From: [REDACTED]
Sent: 23 November 2018 12:21
To: Planning.Responses
Subject: BR/270/18/PL 18 -20 London Road , Bognor Regis PO21 1PY

Our Ref: NW/ARU/18/16A

RE 18-20 London Road Bognor Regis PO21 1PY

Thank you for your correspondence of 5th November 2018, advising me of a Part conversion & extension of existing building to provide 6 No. additional storeys over existing rooftop to provide up to 104 No. student residential units with access from Bedford Street, associated servicing & ancillary accommodation, entrance & new internal stairs to existing building to provide access from Bedford Street. This application may affect the setting of listed buildings & the character & appearance of nearby conservation areas. For which you seek advice from a crime prevention viewpoint.

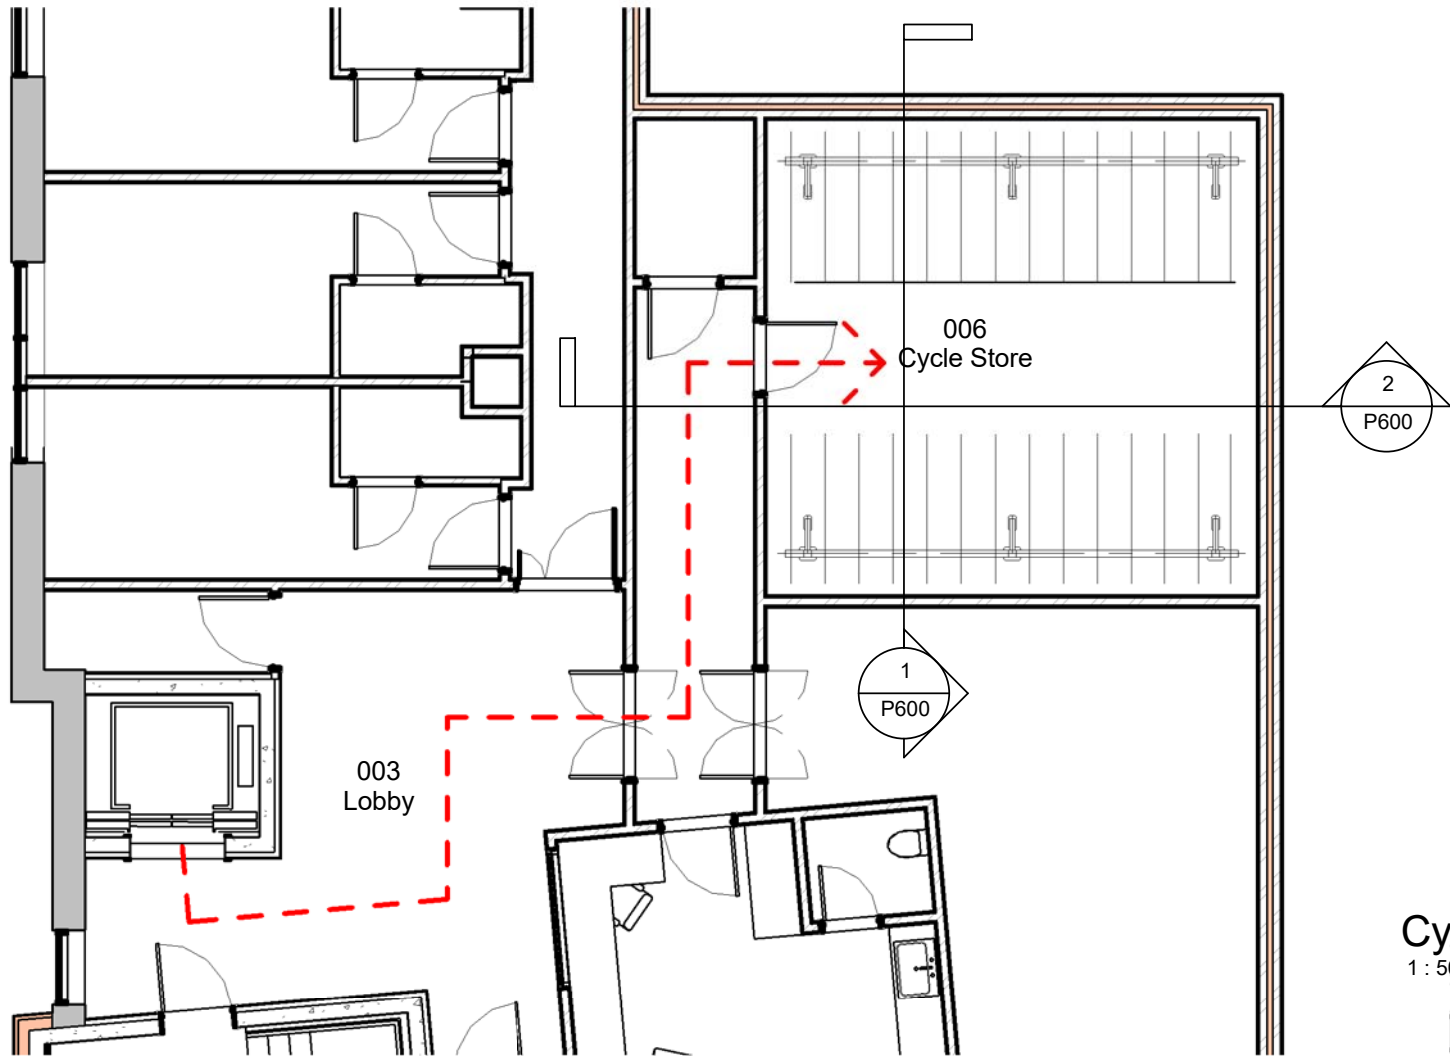
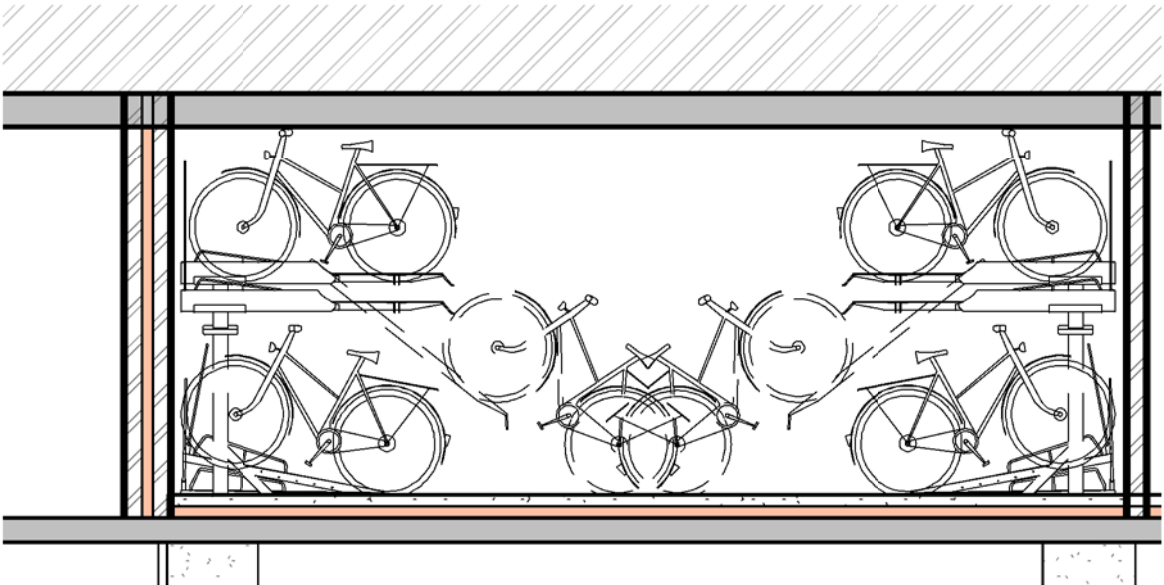
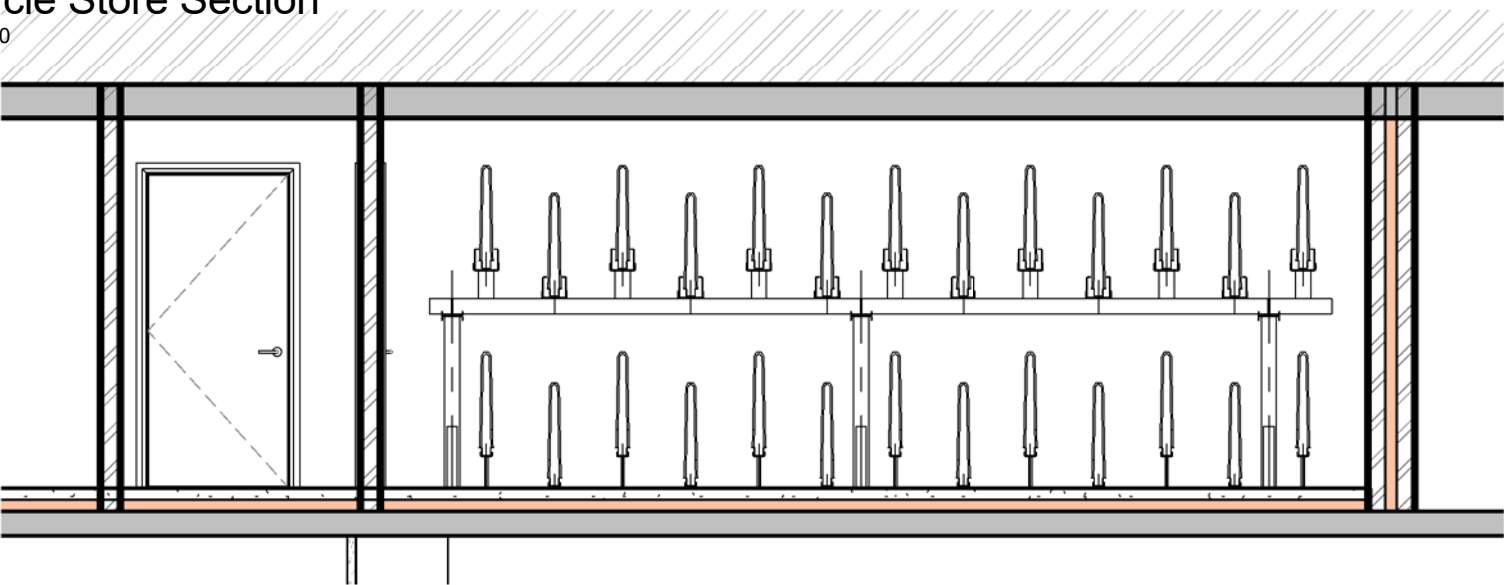
I recommend the internal bike store on the Store First floor level must be fitted with a secure door meeting specifications of either LPS 1175 Issue 7 SR:2 or STS 202 Issue 3:BR2, with controlled access. These specifications will better cater for the hard use of bicycles being constantly pushed through and knocked against it. The bike store should only be accessible by residents and the locking system must be operable from the inner face by using a thumb turn to ensure residents are not accidentally locked in.

The cycle store should be segregated into individual secure compartments containing no more than 30 cycles in each. This helps reduce the unlawful removal of bicycles, parts and equipment, with access restricted to each section which should also have access control.

The cycle store must also be illuminated with low level variable lighting to allow a view into the room before accessing it and then with movement activated lighting to illuminate the room fully on entry. The entry door should have a small glazed panel to allow a view into the store before entry.

SBD Homes 2016 document, paragraph 53.4 and paragraph 54 gives further information regarding cycle racks and secure anchorages specifications.

00-Courtyard Landscape Plan
1 : 100

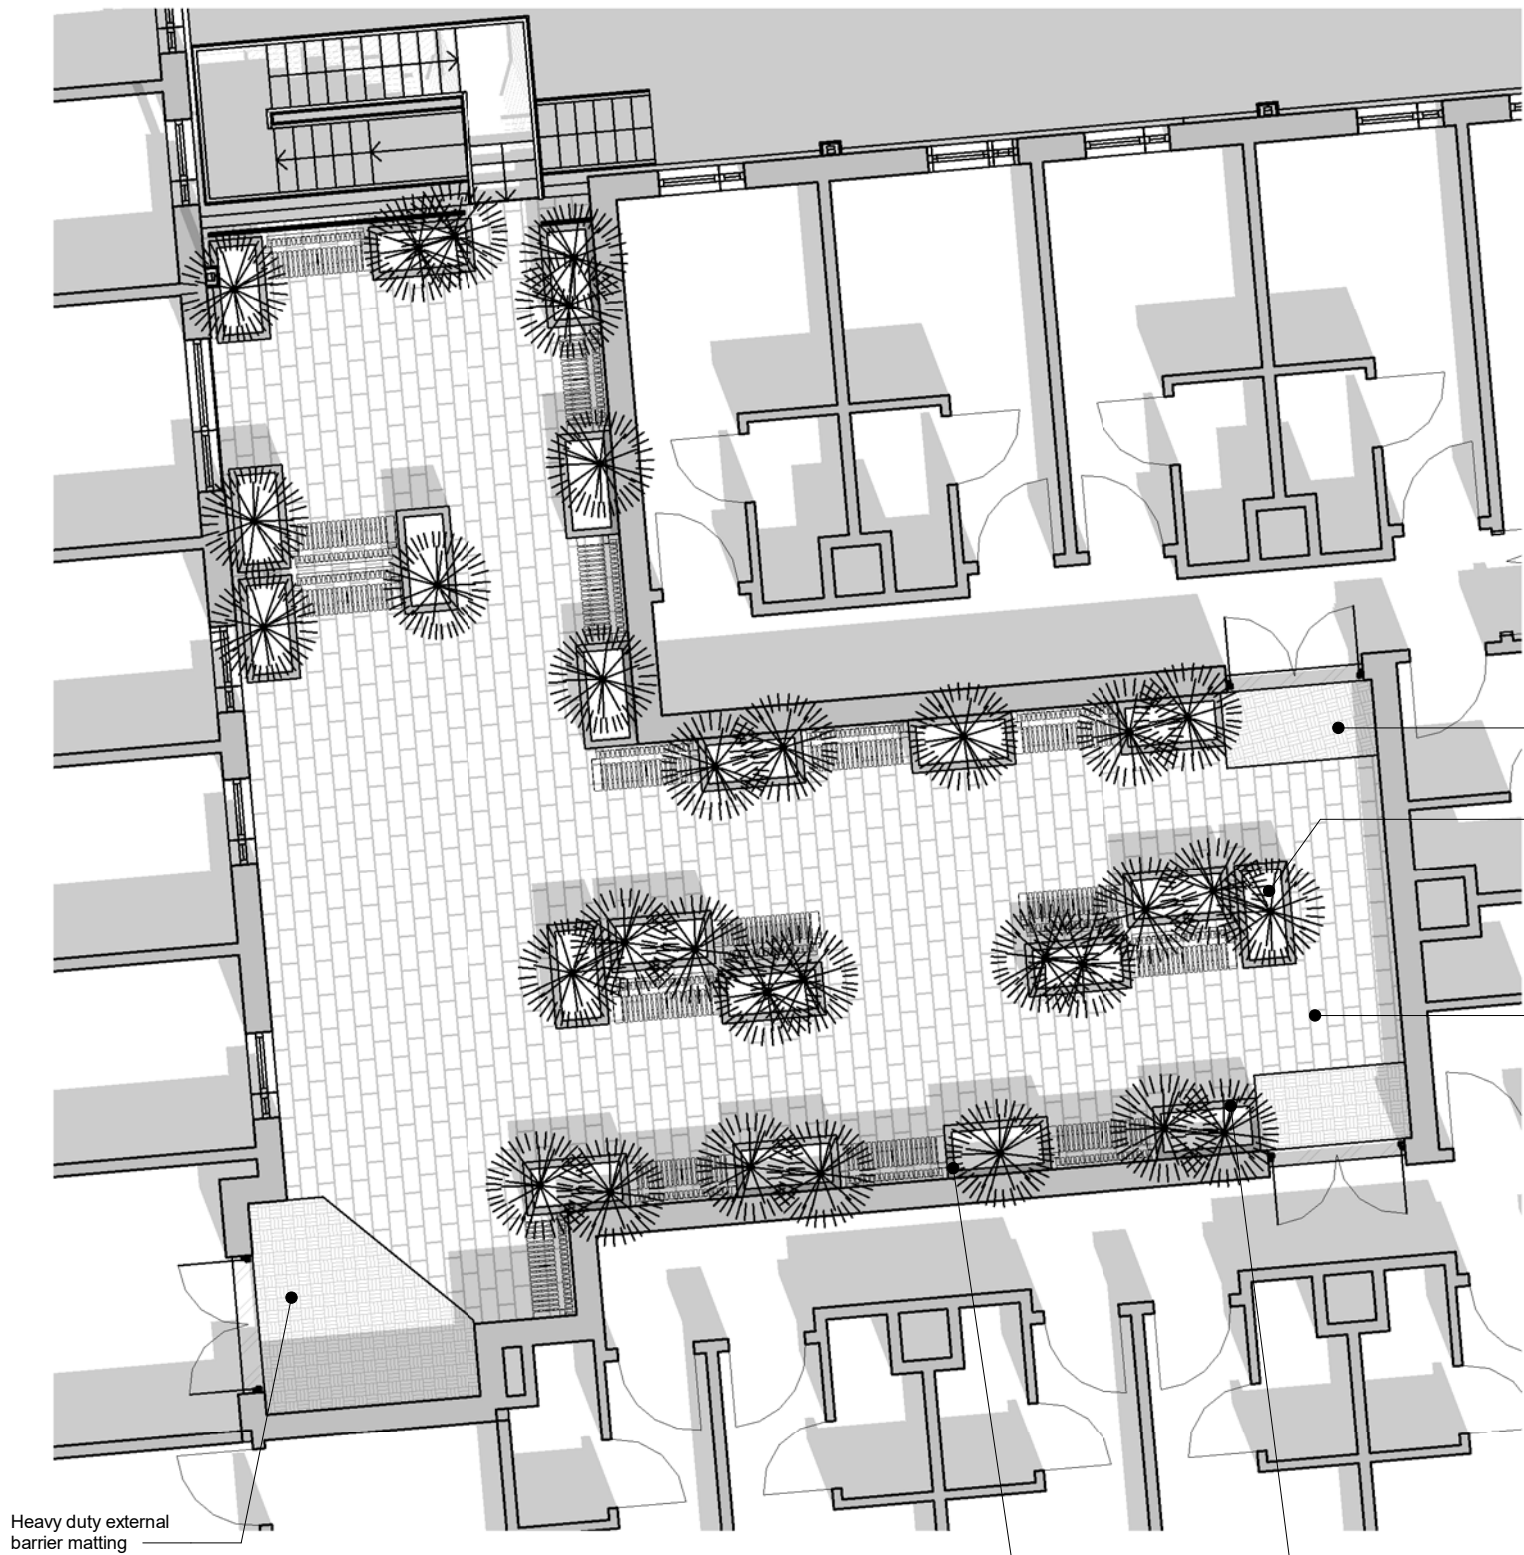
Bedrooms 121,123, and 125 face onto the Podium Courtyard and should be provided with a degree of privacy and private space by suitable planting or alternatively a barrier to deter persons being close to the windows. The court yard should be illuminated with switched vandal resistant 'controlled lighting' to enable it to be reduced or extinguished at appropriate times during the hours of darkness.

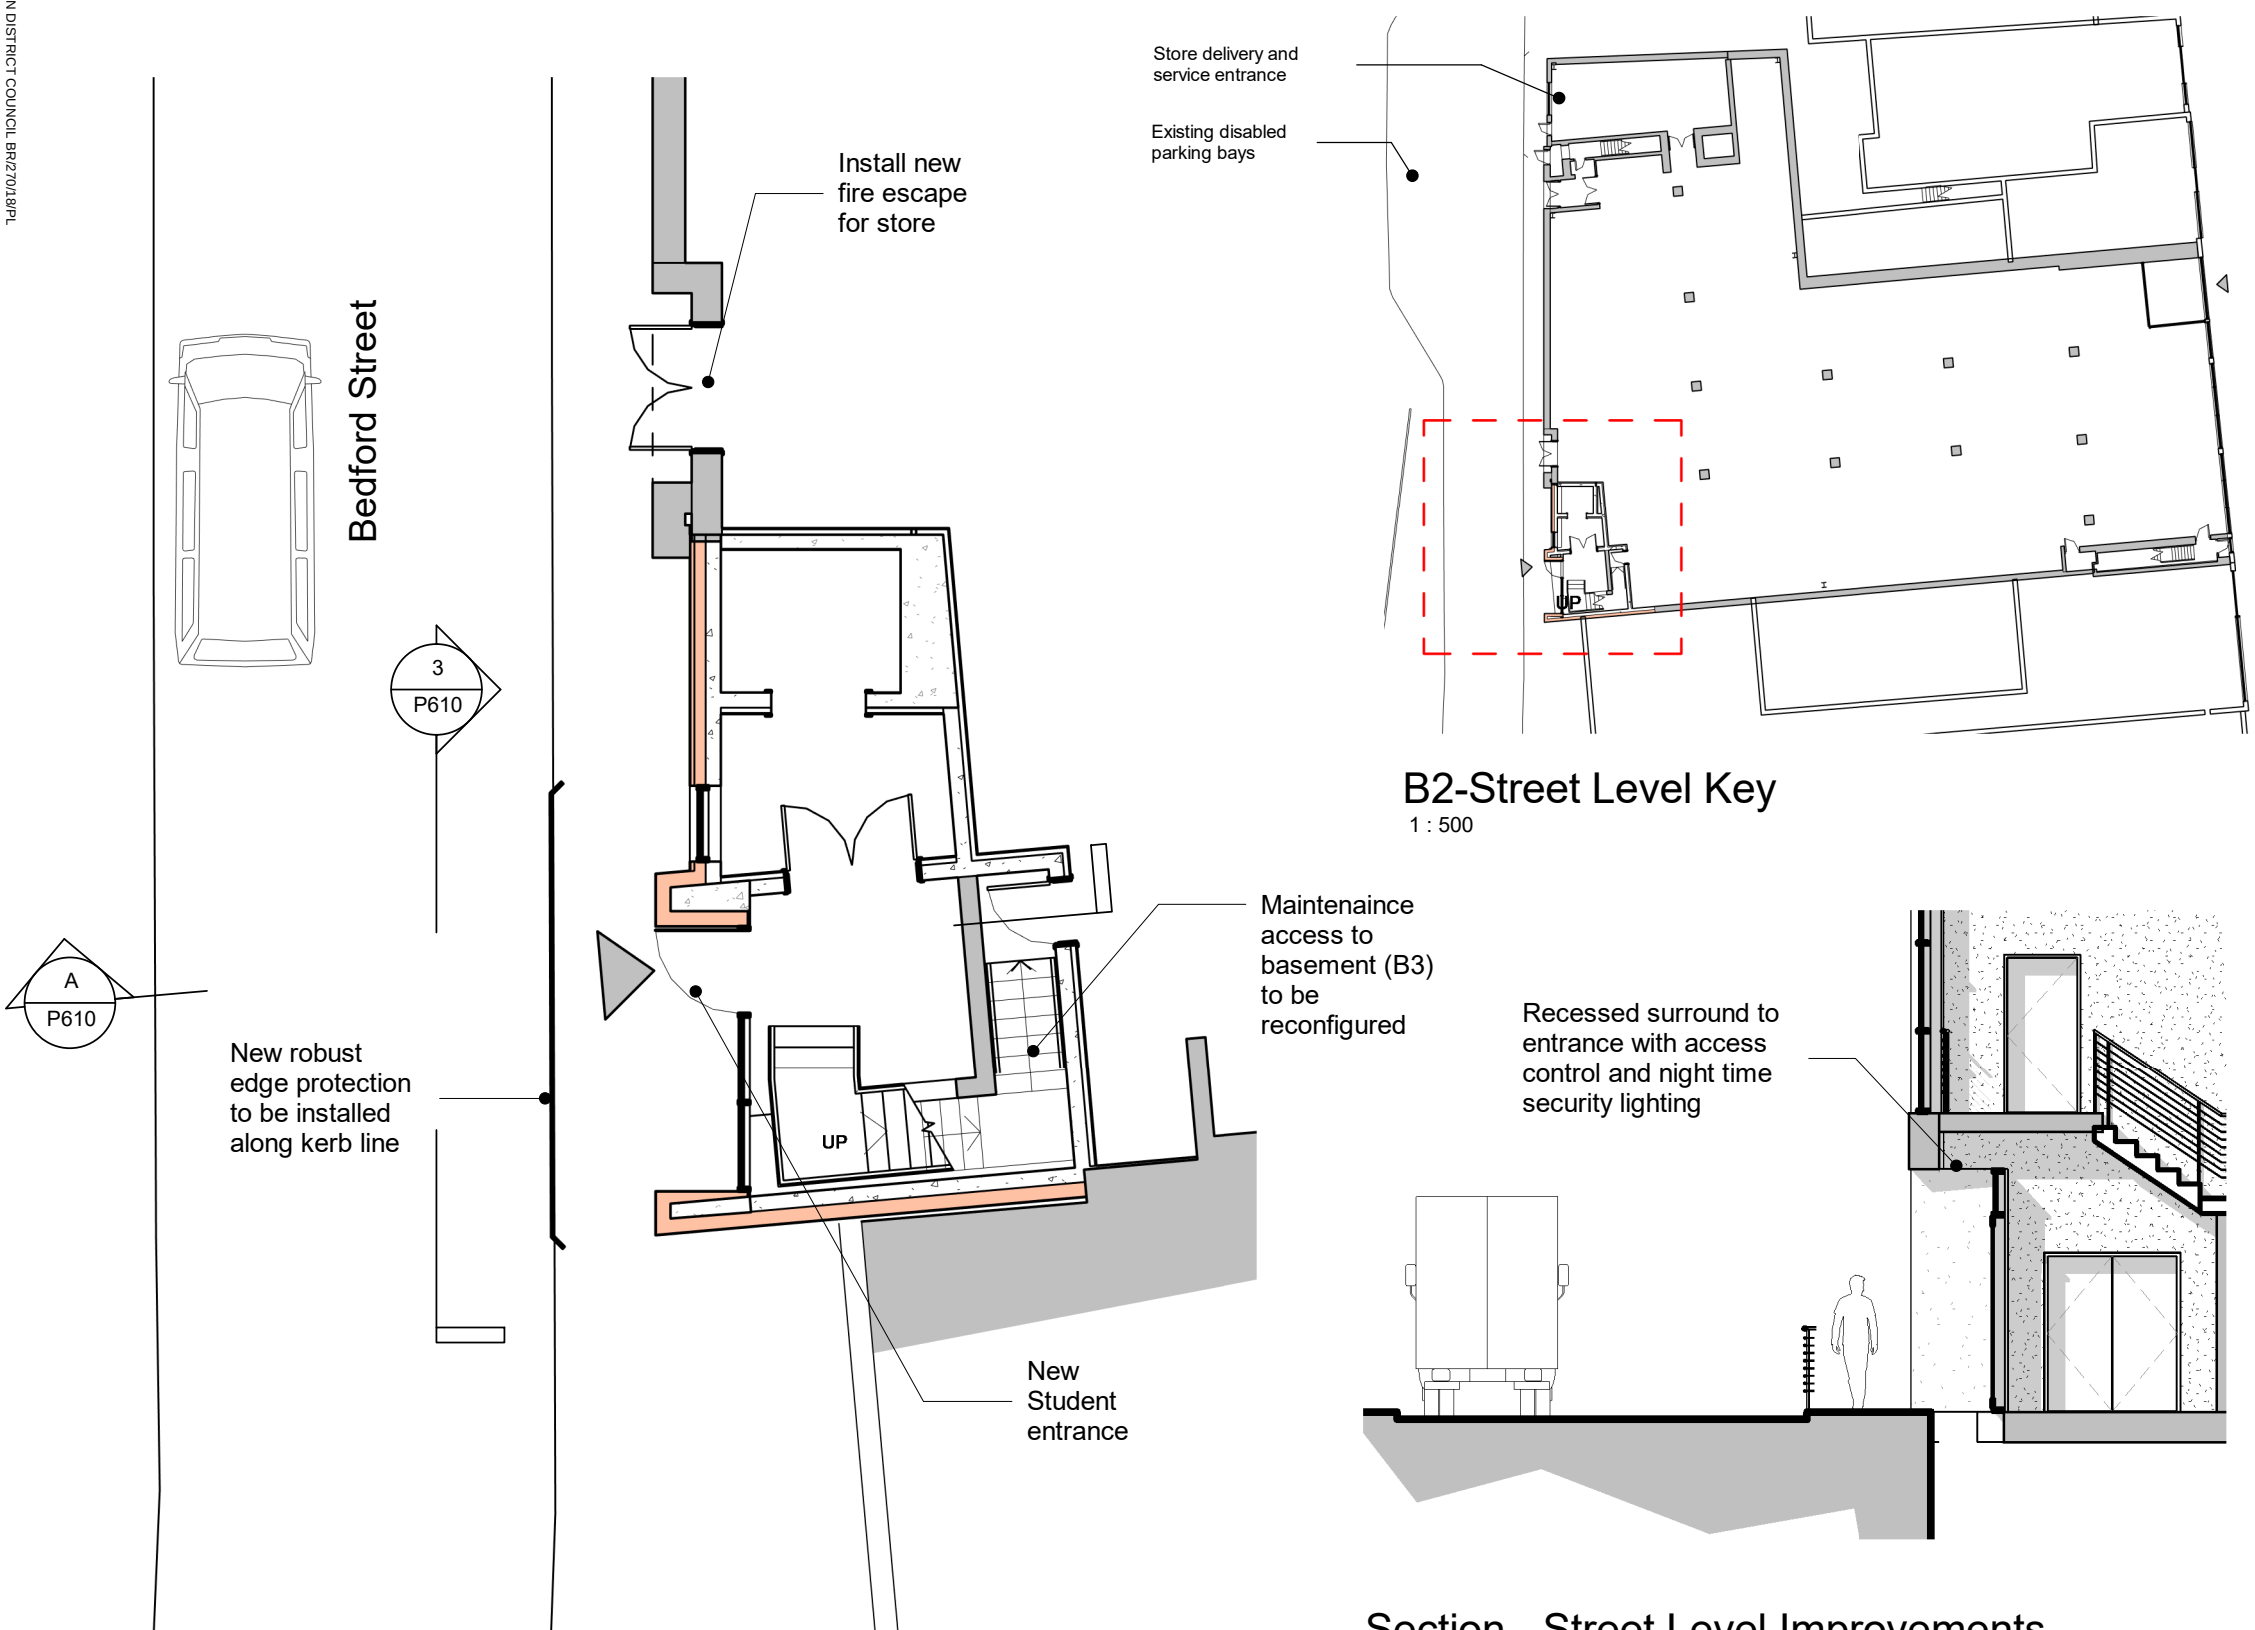
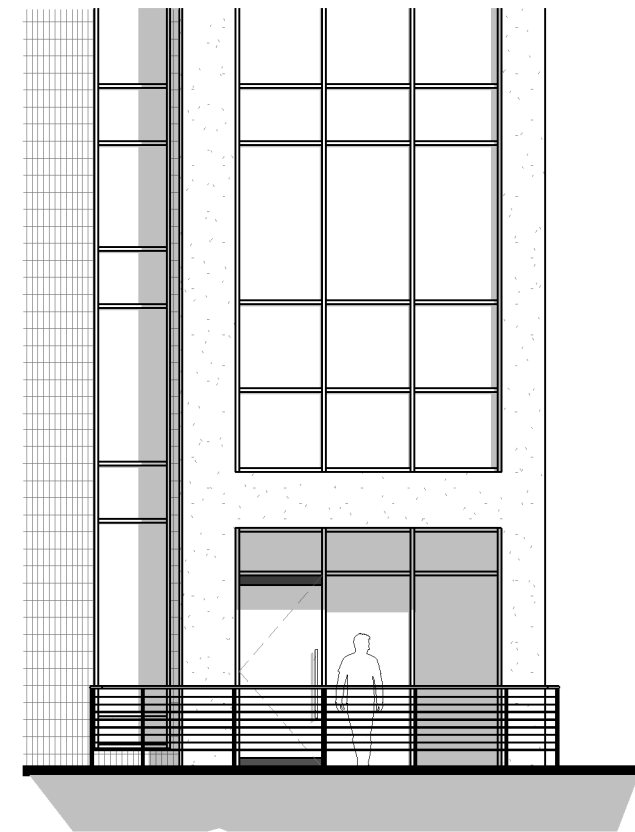
I am pleased to see a pedestrian safety rail is intended to be located outside the student entrance.
